Appeal Decision

Appeal Ref: APP/R5510/W/22/3310267

11 Birchway, Hayes UB3 3PA

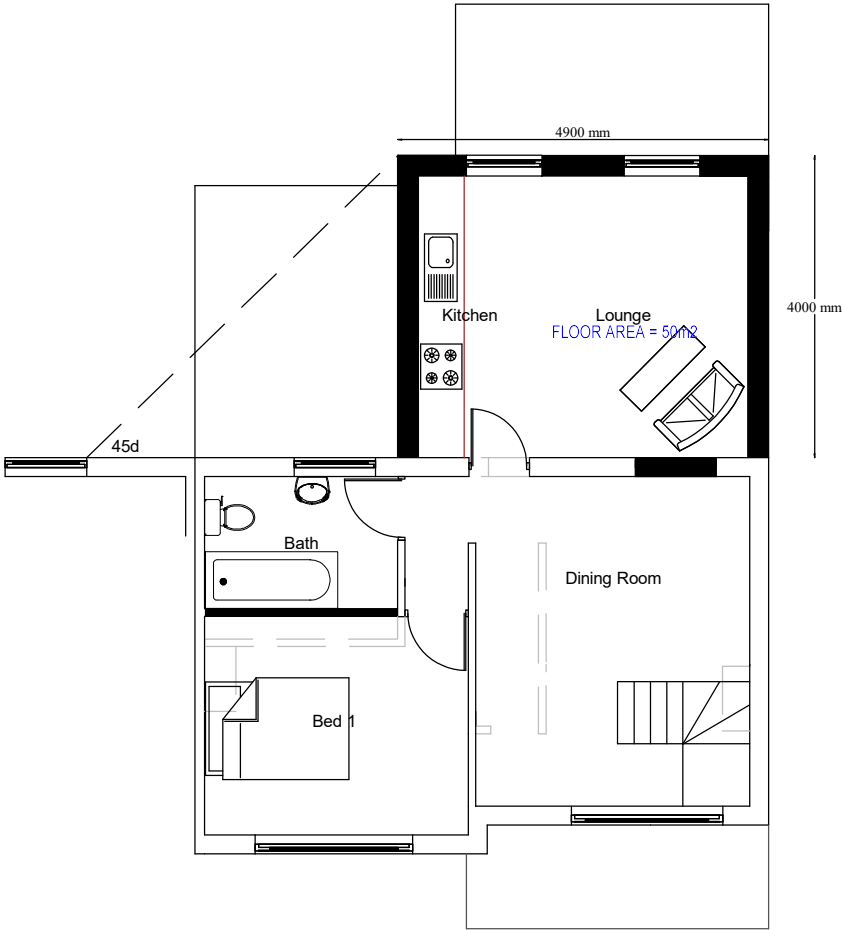
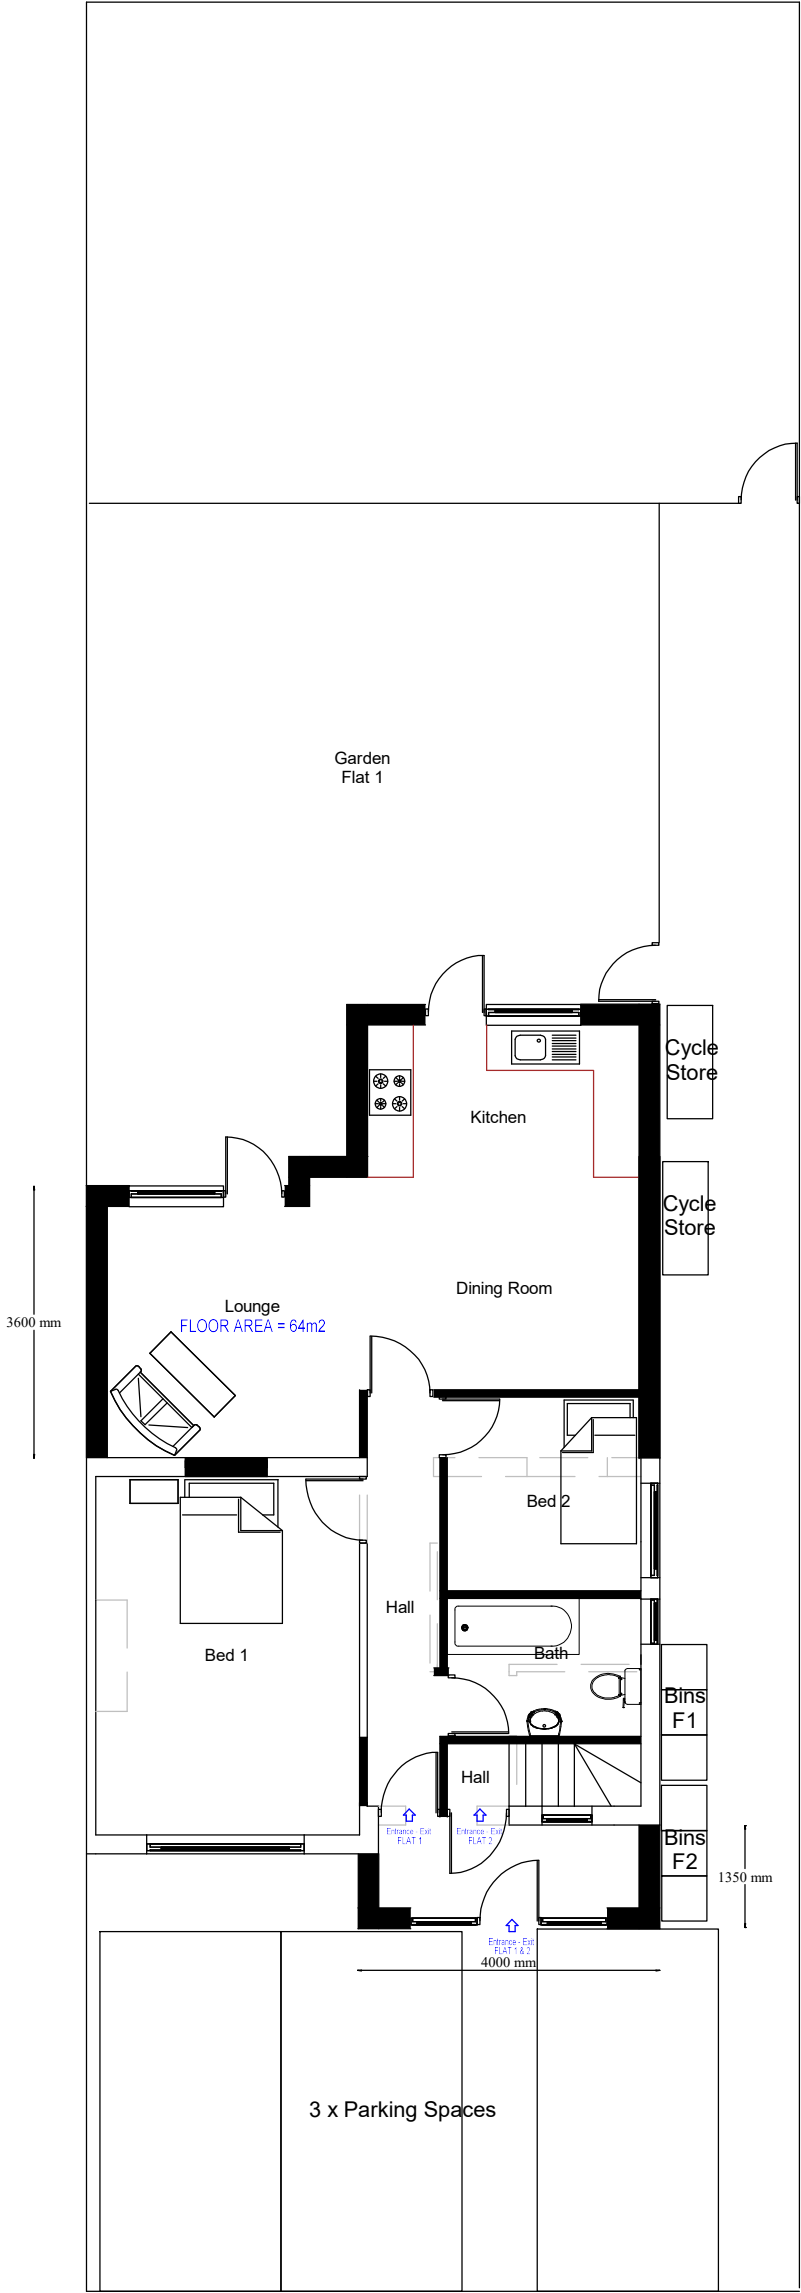
9. The site layout drawing shows the creation of three off-street parking bays at the front of the site, which the Council advises would represent an overprovision of one space when assessed against the maximum parking standards set out in Policy DMT6 of the DMP and Policy T6.1 of the LP. However, the appellant has indicated they would be prepared to remove one of the bays to comply with the parking standards. This could also potentially overcome the Council's concerns regarding the width of the new crossover and the conflict with a street tree outside the site, albeit no amended plans have been provided to this effect.

10. The above notwithstanding, parking bays must be appropriately sized and laid out to ensure they are useable in practice and do not cause any obstruction of the public highway. It is difficult to ascertain from the drawings whether the proposed bays meet the Council's minimum dimensions of 2.4m in width by 4.8m in length. Either way, it is notable that the layout provides little, if any, space for circulation around the bays, with the bays being positioned hard up against the front wall of the new porch and the edge of the pavement. This

would render the arrangement impractical and would be likely to result in vehicles overhanging the public footway and causing an obstruction to pedestrians. While removal of the third bay may potentially allow for a different parking arrangement, I have no plans which demonstrate that an acceptable layout would be achieved. This is not something which should be left to a planning condition.
